Fast Track Application - 77 Dorset St

Hi, we did receive your submittal. It looks like this application accounts for the closet work only. You don't need

17 Dorset - New Kitchen (same layout as existing) and closet removal.

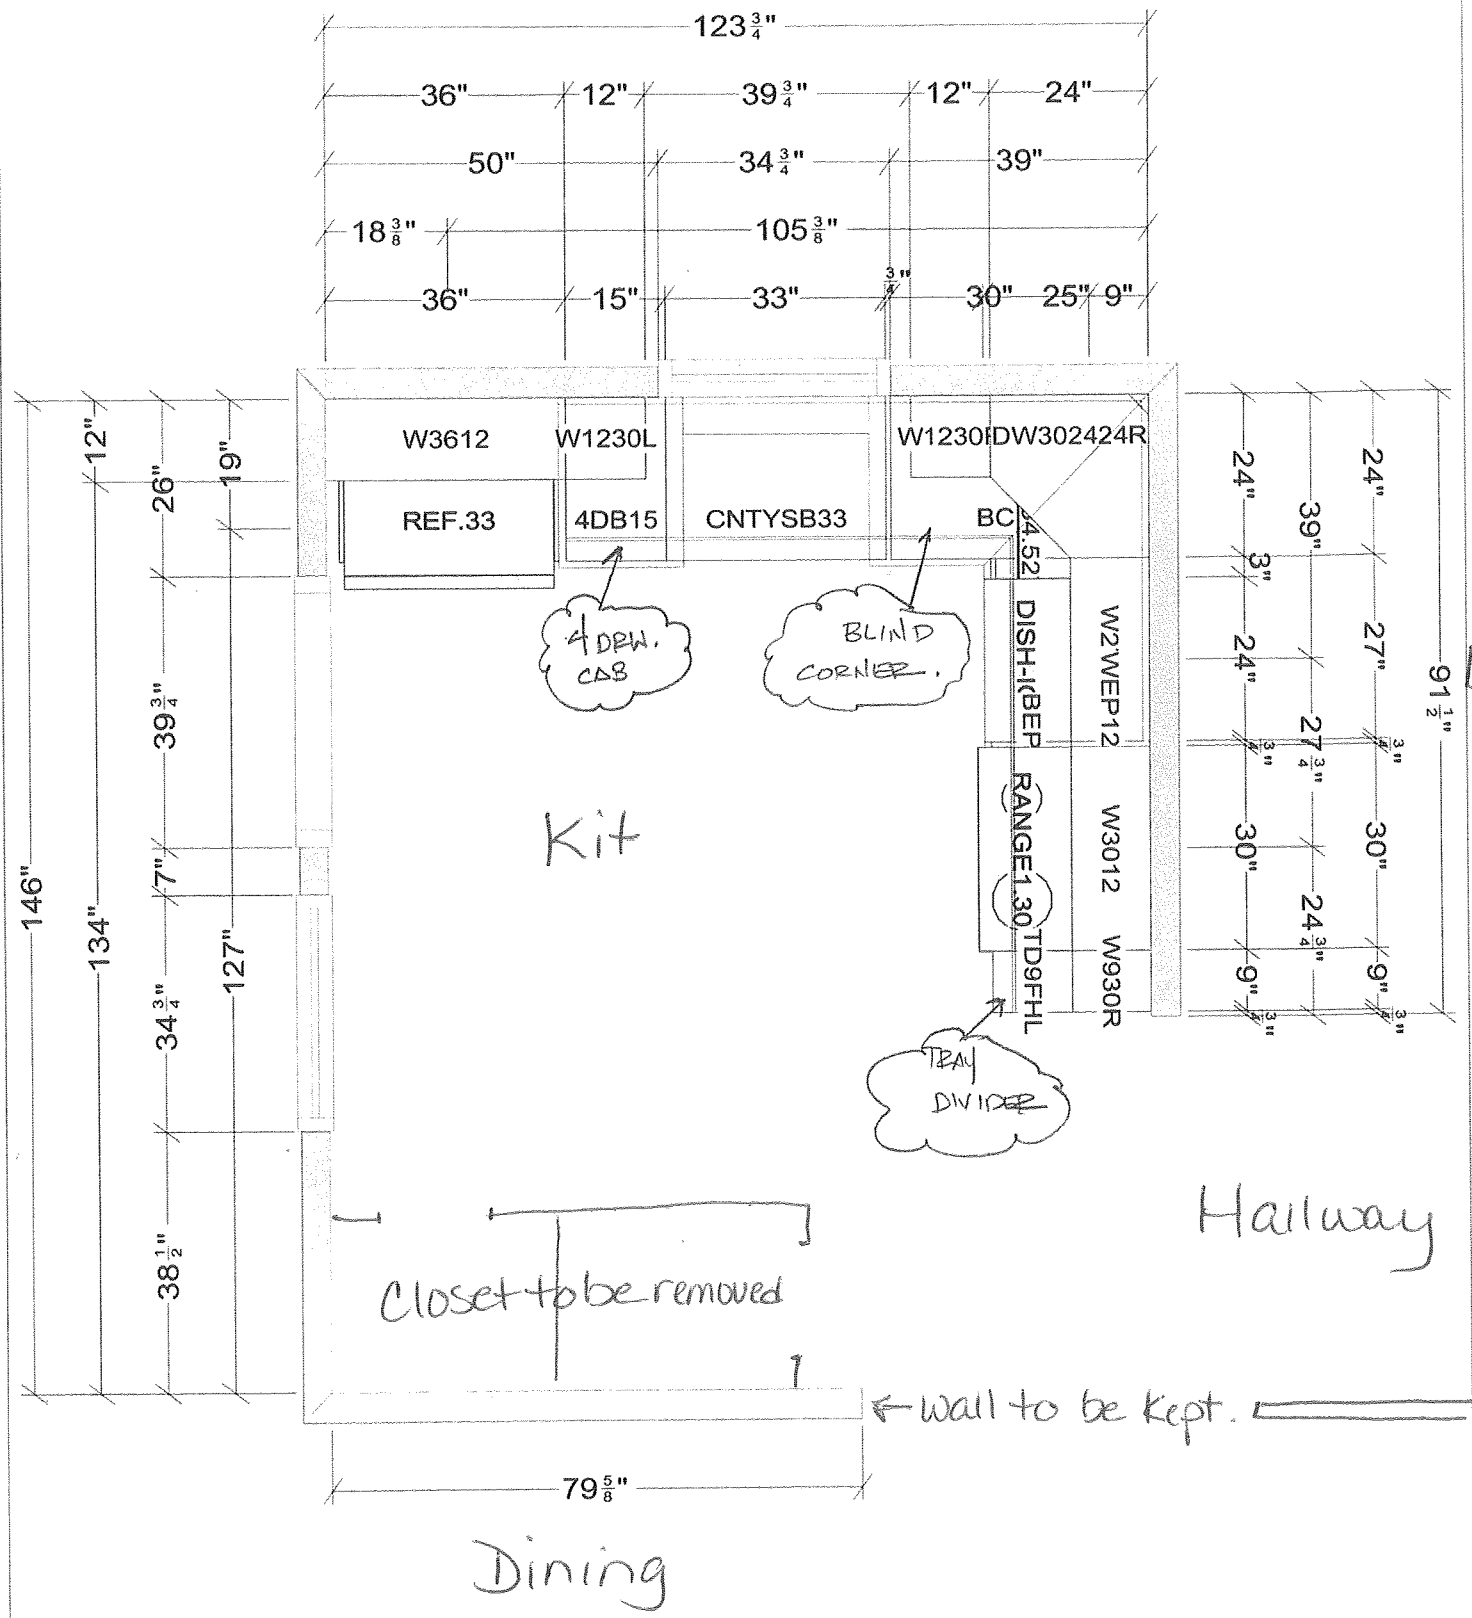
a permit to take down and change up cabinets (unless you are taking down or putting up walls to do so). That being said, and assuming the only permitted work you are requesting is the closet, we do need some construction drawings on how you are constructing that closet. According to your documents, we would need a cross section/framing detail just showing how you are closing in that new closet. Please get that to us ASAP.

Hi, sorry, also a full floor plan is a requirement, not just the room within that floor you are working in. The floor plan needs to be dimensioned or to scale and show all rooms on that floor and the location of work "highlighted" in some way. Please provide a full floor plan with the framing detail requested before.

NOTE: Please make sure we get the full floor plan and framing plan requested/required in previous e-mails. This needs to be provided for this application to be reviewed.

Are you removing any walls? Then are you constructing new walls to close in that "new" closet? That's considered construction and you need to show us how that new wall is being built. A floor plan has nothing to do with showing the construction of any wall. A full floor plan is the requirement to see where, within the building, you are working.

We are removing closets, not constructing closets, so I'm not sure what you need for: "we do need some construction drawings on how you are constructing that closet". Is a full floor plan highlighting where the existing closets are that are being removed sufficient?

There is no new closet. We are removing closets.
